**PNM Comments
Development Review Board
Public Meeting to be Held on January 13, 2021**

**PNM comments for Approval for DRB # PR-2020-004604 (SI-2020-001467) Site Plan
(Holly Ave NE between Ventura St NE and Desert Shadow Way NE)**

**A1.10**  
PRELIMINARY SITE PLAN

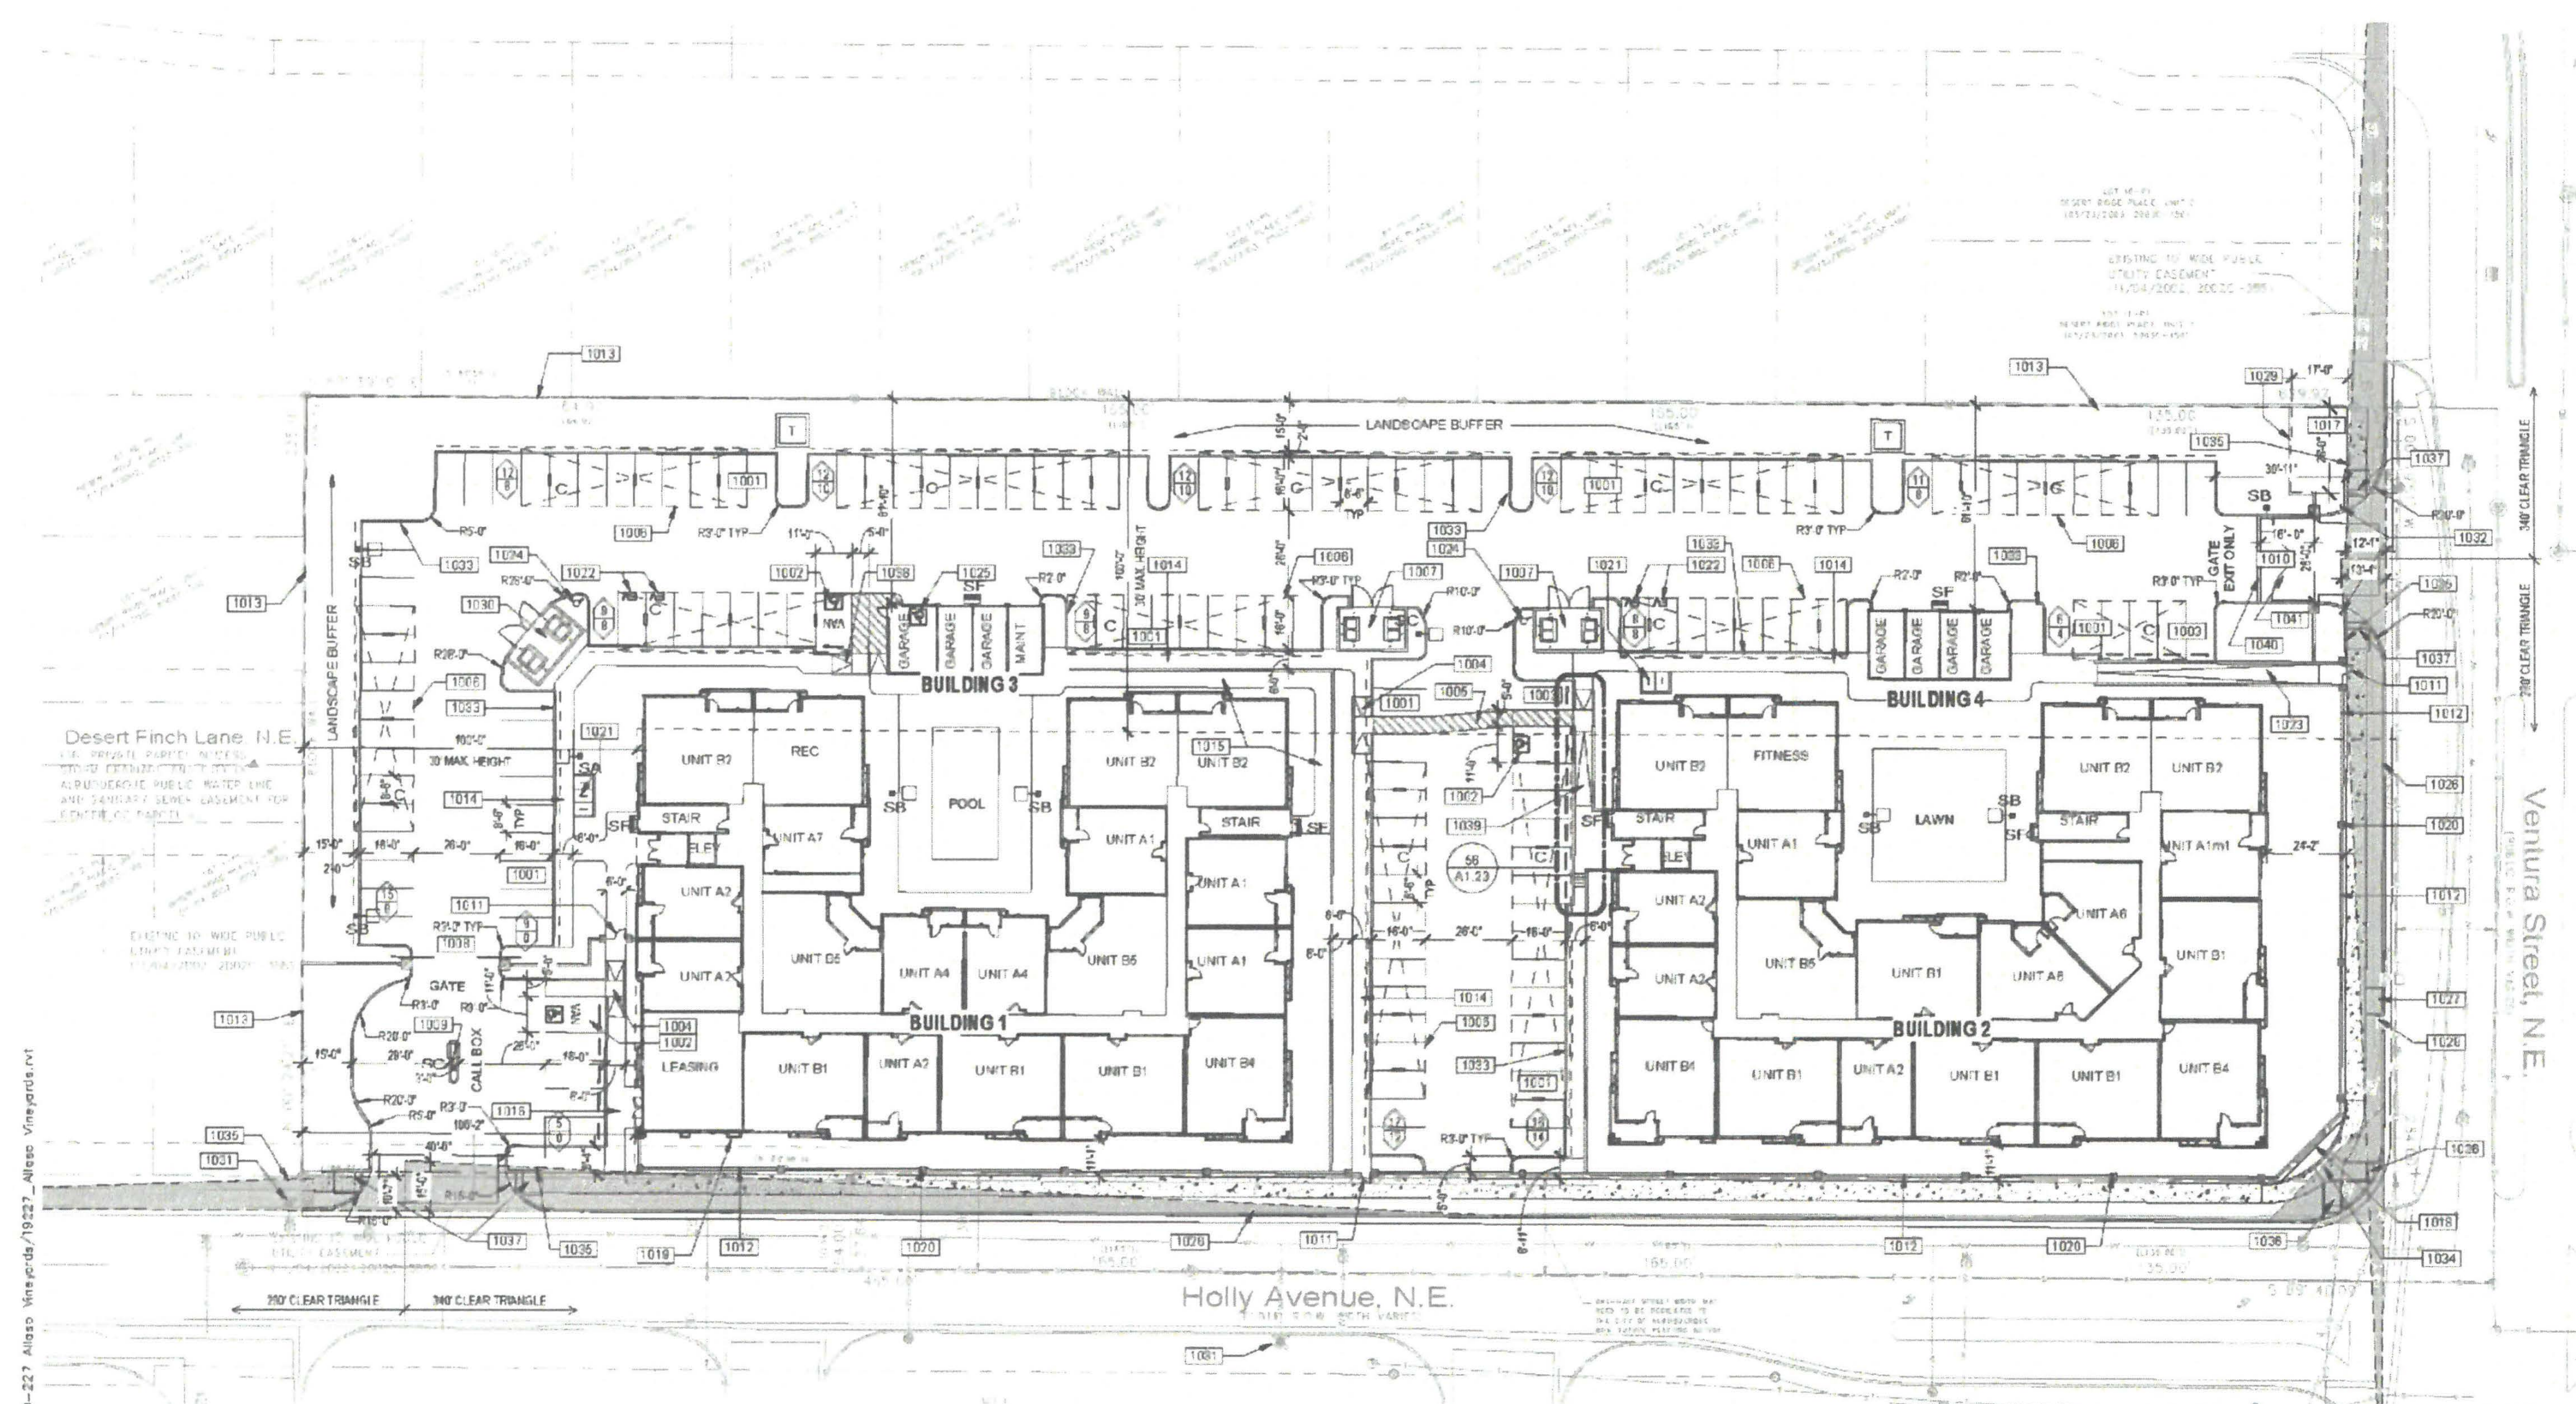
4. There is an existing overhead distribution line immediately adjacent on the project's east side along Ventura St NE. If existing electric lines need to be moved or undergrounded, then that is at the developer's expense. Please contact PNM at www.pnm.com/erequest for PNM to review.

5. Safety clearances for construction and final design of the building(s) near the distribution line along Ventura St NE shall show compliance with NESC requirements prior to any approvals. Refer to the PNM Electric Service Guide at www.pnm.com for specifications.

DRB SUBMITTAL  
DATE: DECEMBER 17, 2020 ORB #:  
JAN 5, 2021 JAN 18, 2021  
**LS-01**  
LANDSCAPE PLAN

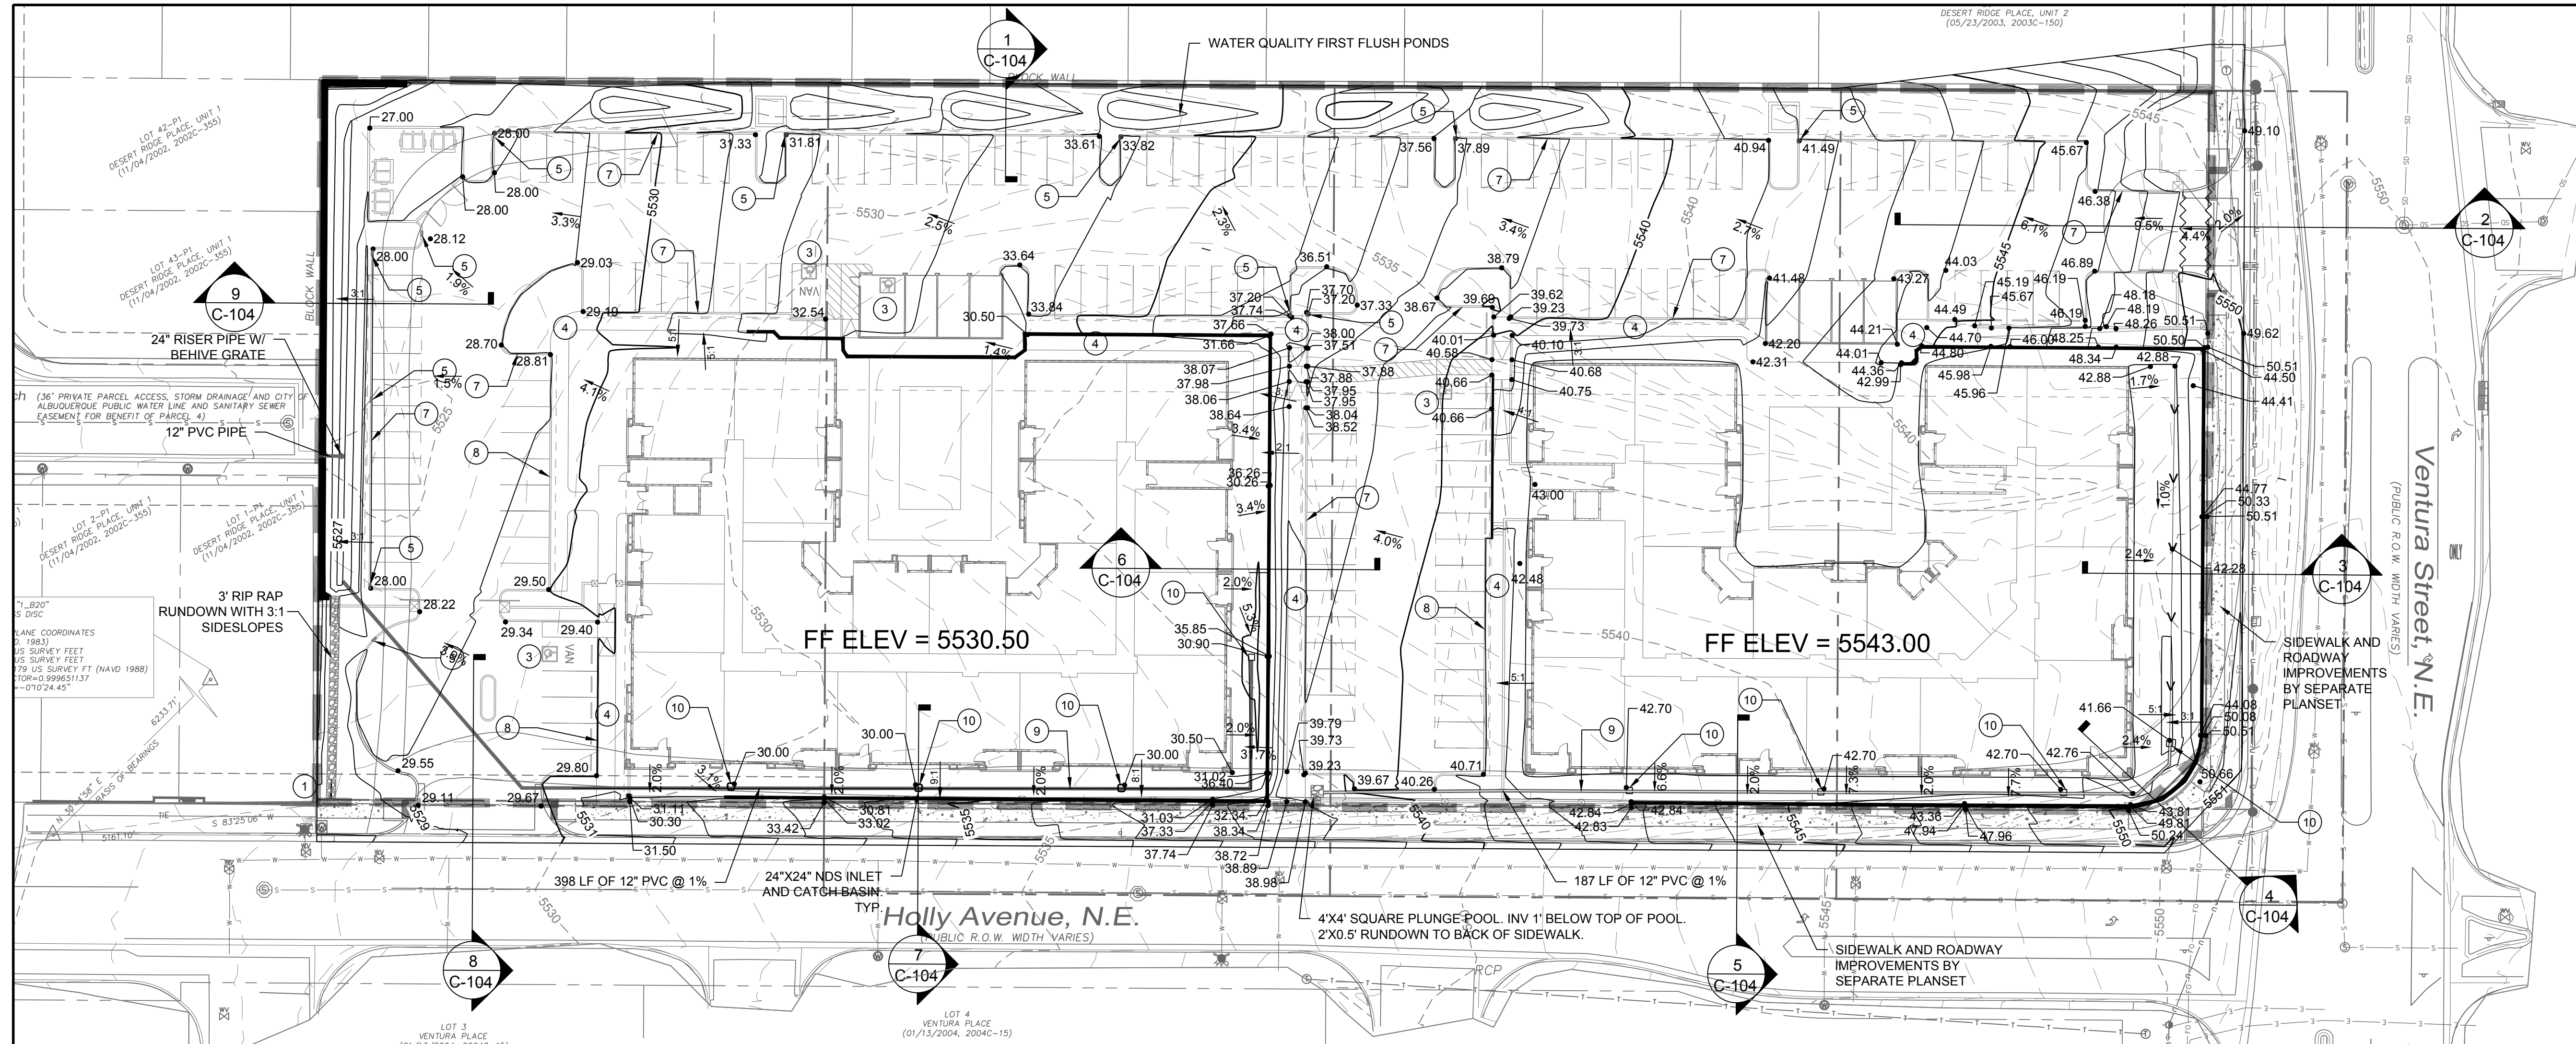
3. Ground-mounted equipment screening will be designed to allow for access to utility facilities. All screening and vegetation surrounding ground-mounted transformers and utility pads are to allow 10 feet of clearance in front of the equipment door and 5-6 feet of clearance on the remaining three sides for safe operation, maintenance and repair purposes. Refer to the PNM Electric Service Guide at www.pnm.com for specifications.
